Harnett County Government Complex
307 Cornelius Harnett Boulevard
Lillington, NC 27546

Re: Status of Improvement Permit Application #05-5-12664 Lt 69 Forest Oaks

On July 29, 2005, an Environmental Health Specialist from the Harnett County Health Department attempted to evaluate your property for the purpose of issuing an Improvement Permit. This individual was unable to evaluate your property for one or more of the following reasons.

Revised
 SITE PLAN APPROVAL
 DISTRICT KAZOR USE SFI
 #BEDROOMS 3
8/2/05 PJR
 Date Zoning Administrator

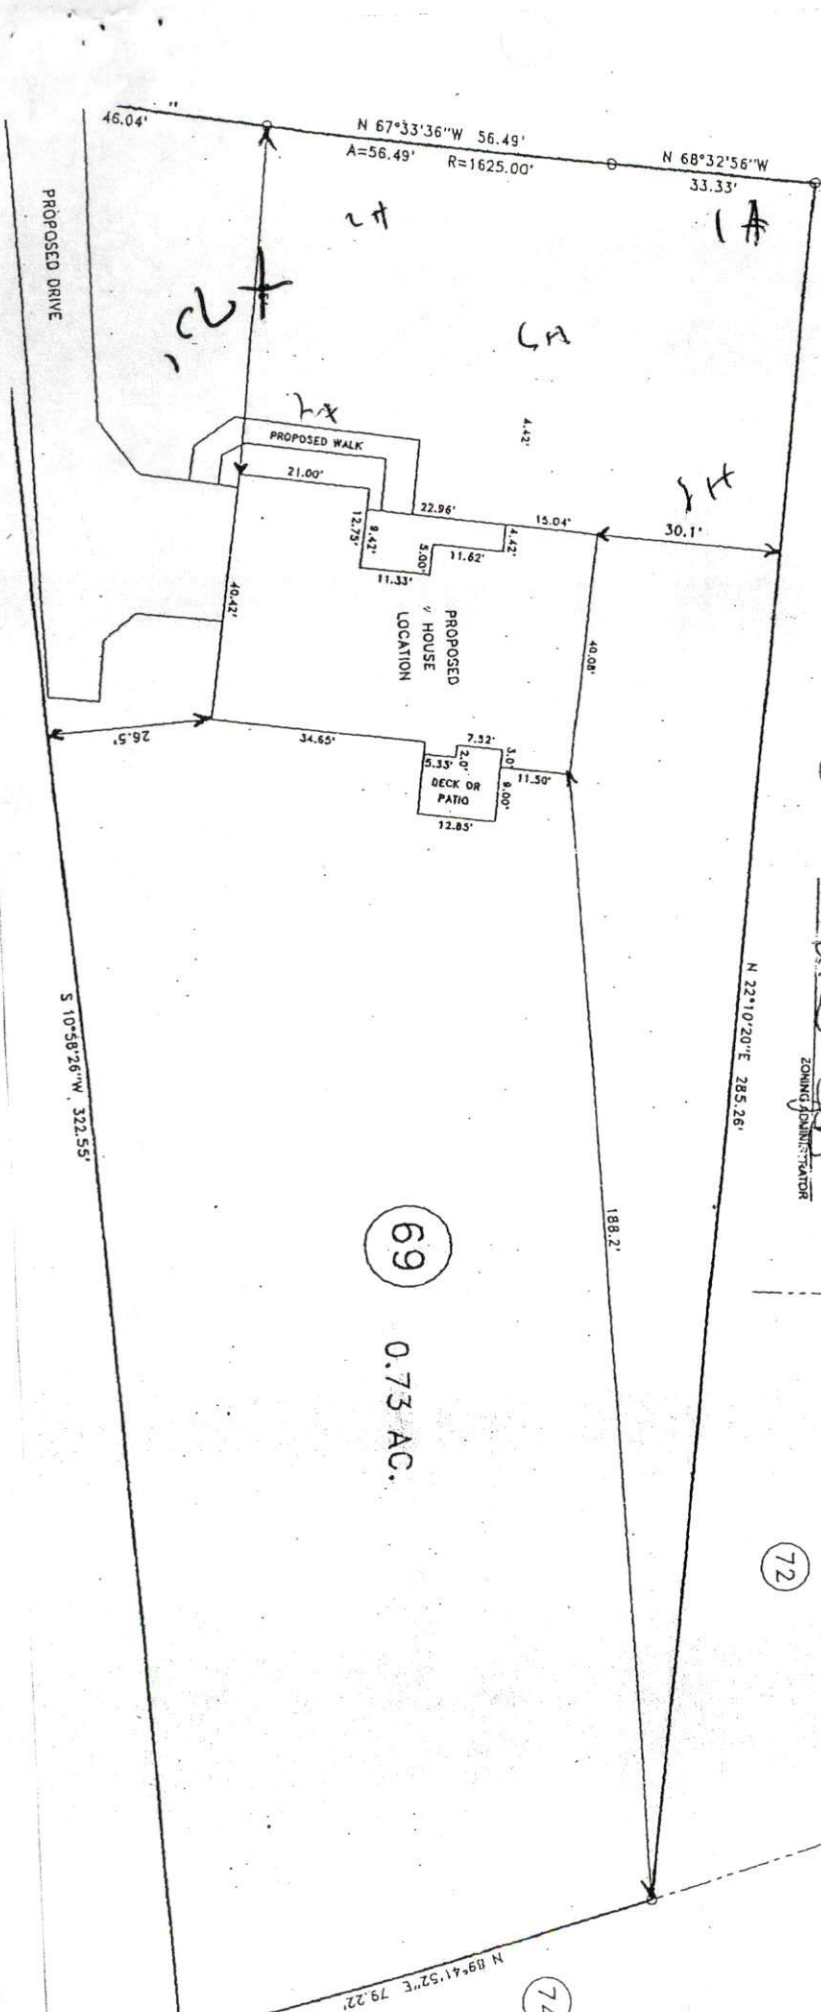
- 1. Property lines/corners not marked or labeled
- 2. House corners not marked or labeled
- 3. Directions not clear to property
- 4. Property needs brush or vegetation removed
- 5. Backhoe pits required
- 6. Other **Move house back 15' which would be 70' from front property line (see enclosed plot plan) Resubmit your revised application to Central Permitting and reconfirm through the automated system.**
